From: Lee Mar [REDACTED]
Sent: 28 February 2012 11:04
To: Eve Hearsey
Cc: Christine Tetlow; Philip Satchell; Ian Courtneidge
Subject: RE: FORMAL CONSULTATION - FG/16/12/ - COUNTRY FAYRE (ASDA), LITTLEHAMPTON ROAD, FERRING
 Dear Eve

This development at Country Fayre has already been approved and Asda wish to make some changes to the overall scheme which are identified within this application for a Minor Material Amendment (MMA). One of the changes being that the landscaping/planting will be increased to that of the earlier permission.

Proposed Site Plan

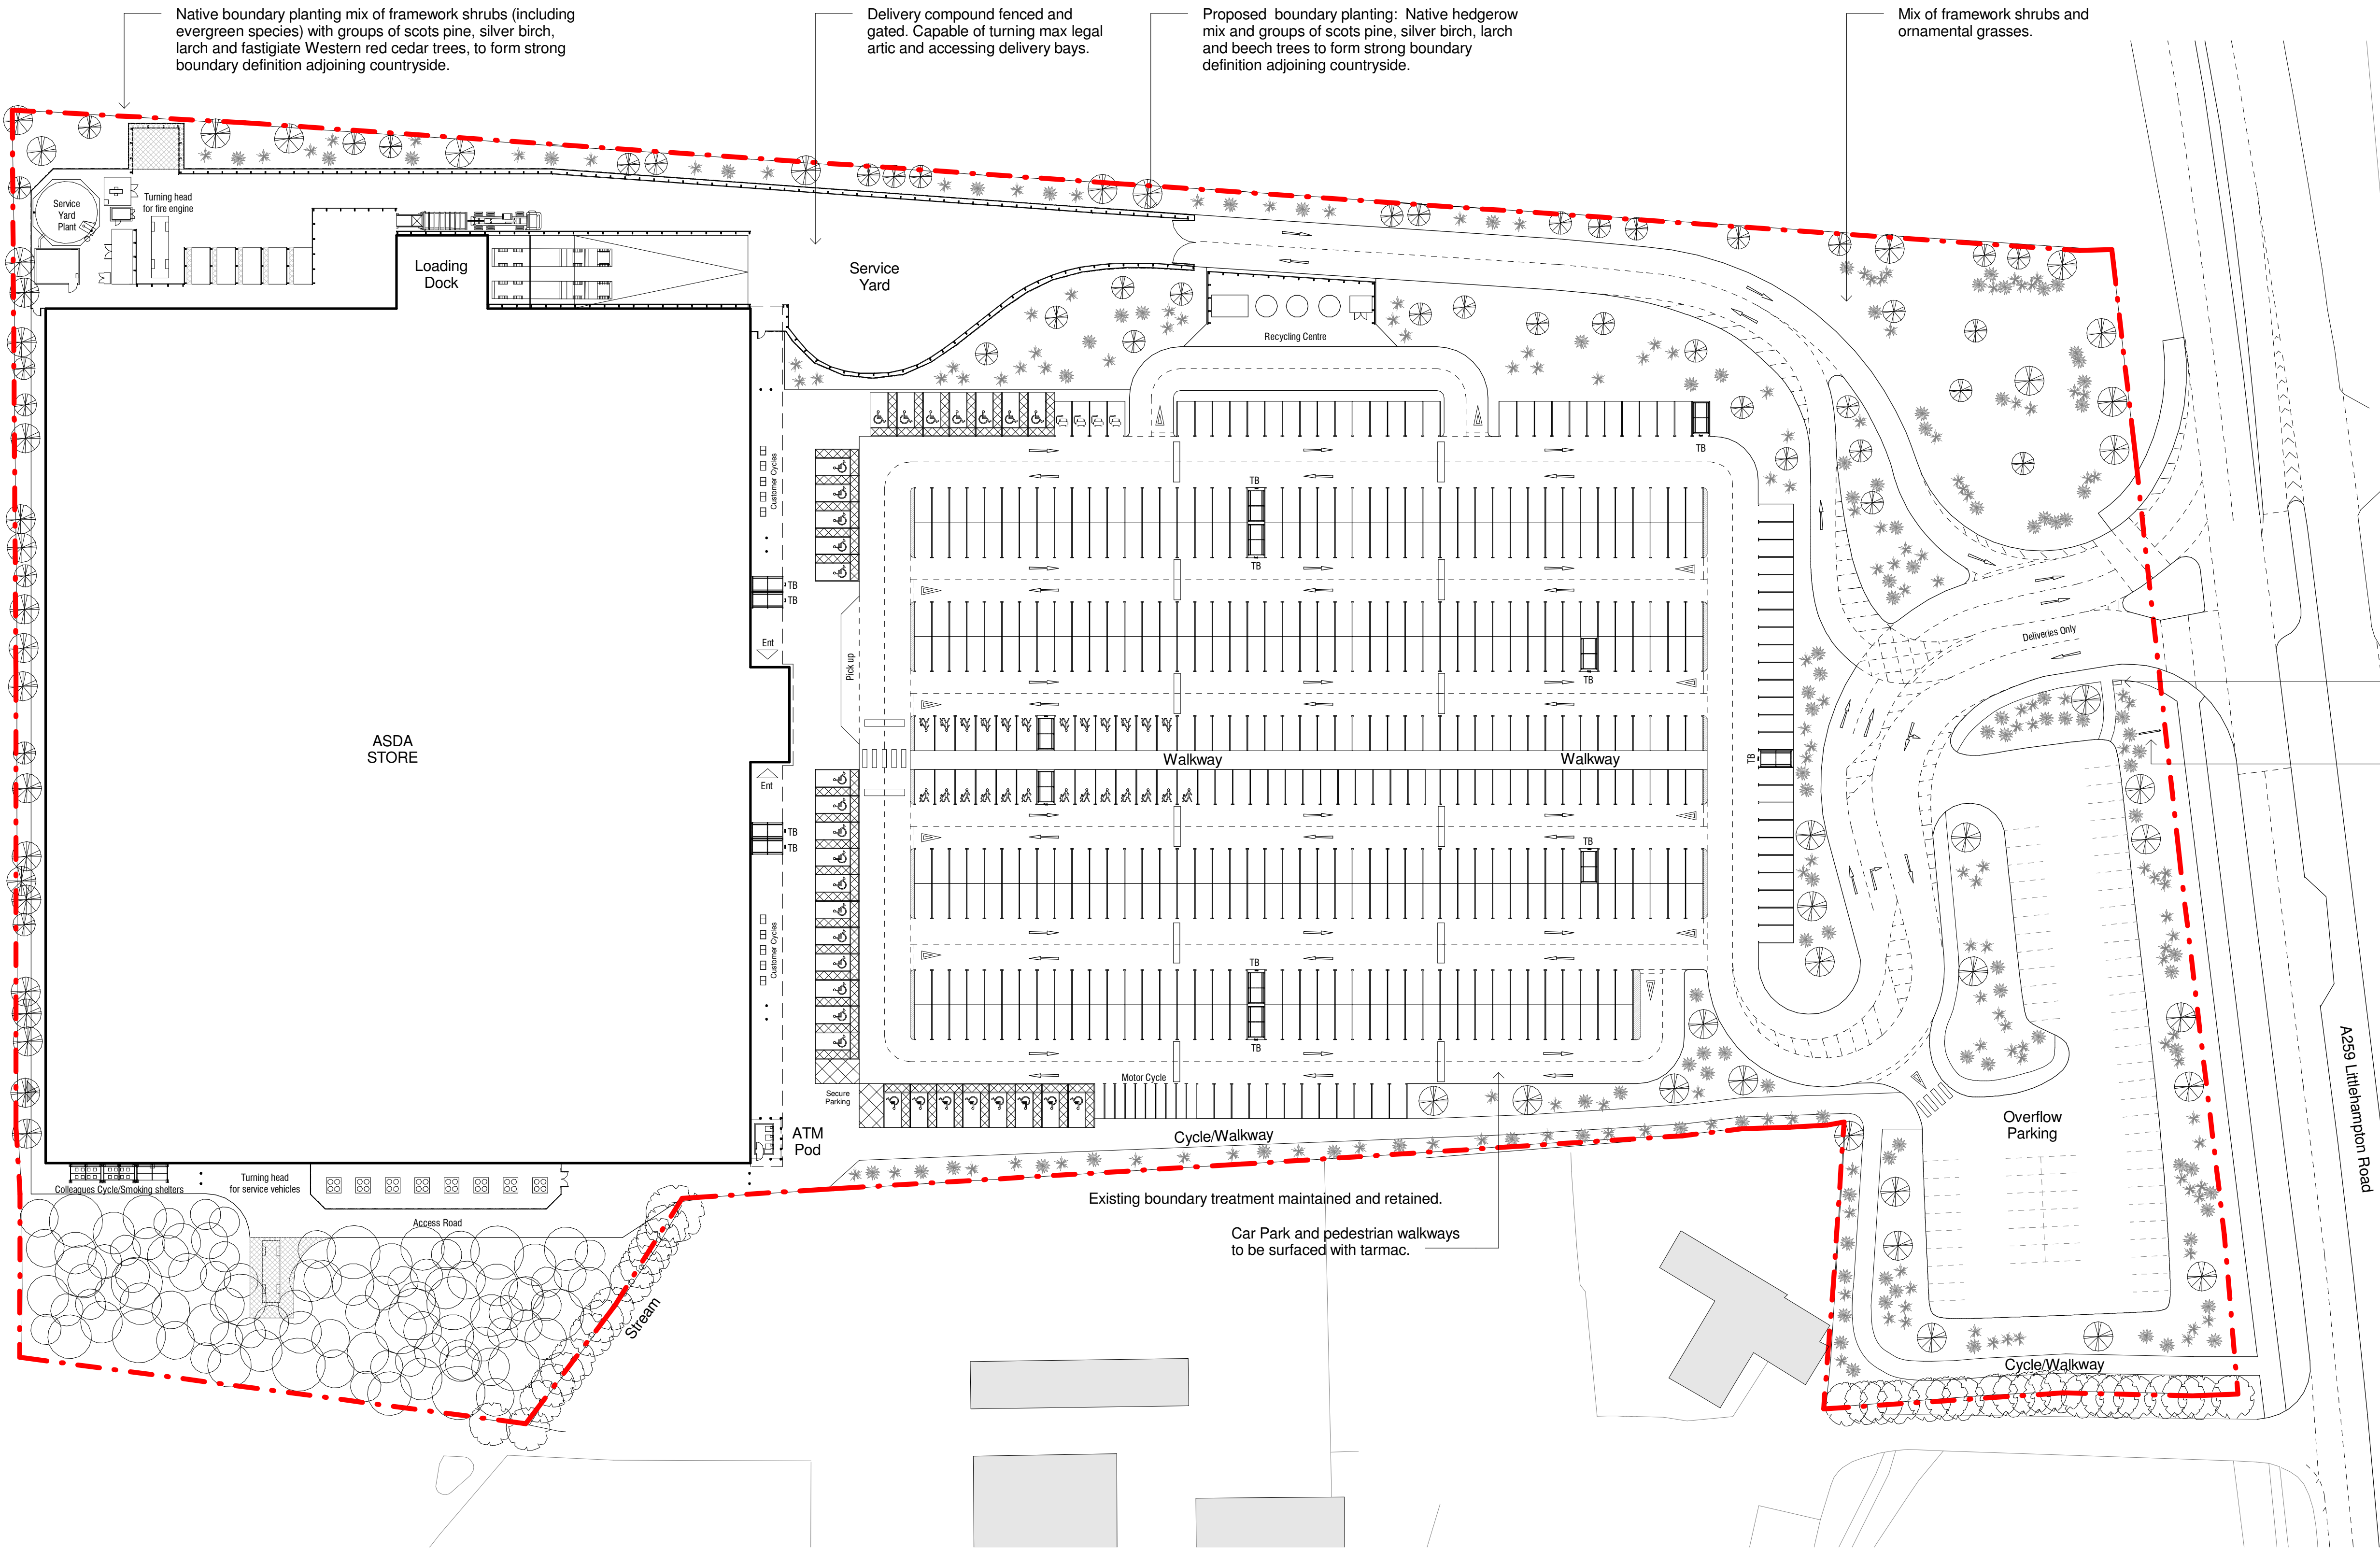
The width of the western boundary measures 3.5m. The proposed planting of Scots Pine, Silver Birch and Beech trees will mature and their branches will overhang the access driveway to the loading dock/Service yard. Vehicles using this route will be high sided HGV. Tree planting would need to set at a sufficient distance to reduce the need for drastic pruning work, eliminating the creation of an un-balanced line of trees and increase their life expectancy. It is therefore recommended that the verge is widened to accommodate broad spreading trees or that they are planted at a distance of 0.5m from the boundary to allow at least 3m lateral branch growth without the need for pruning hard back from the driveway. Please note that the planting of Larch is not recommended due to its recent association with the fungal disease Phytophthora. I would suggest provenant and locally sourced English Oak as a possible replacement for Larch.

The overflow car park to the north east is opposite to the planting area (approximately 30x40m) north west and from a visual perspective as viewed from the A259 Littlehampton Road appears unbalanced. It would be appropriate to provide a similar planting scheme/provision for space by halving the overflow car park and supplement the mix of framework shrubs and grasses with trees, suggesting tall, cleared stemmed Scots Pine trees in groups of 3. This would effectively soften and enhance the entrance, adding a natural and prominent landscape feature that would become visible from the highway.

The width of the western boundary and the proposed planting has not changed from the original approved scheme. However, the points regarding the planting and its location will be forwarded to the landscape architect.

Whilst we respect his comments regarding the northern boundary, we have as far as possible tried to maintain the character of the original consent. However, through our discussions we have removed overflow car park 1 to provide a respectful landscape boundary adjacent to the agricultural land to the west and have maintained a suitable provision of overflow parking as per the original application and it is worth noting that the proposed scheme provides a 9m zone of landscaping between the overflow car park and the back of the existing footpath.

The Landscape Architects are currently amending their plans to suit the amended layout and once we have received the completed drawing we will forward you a copy.
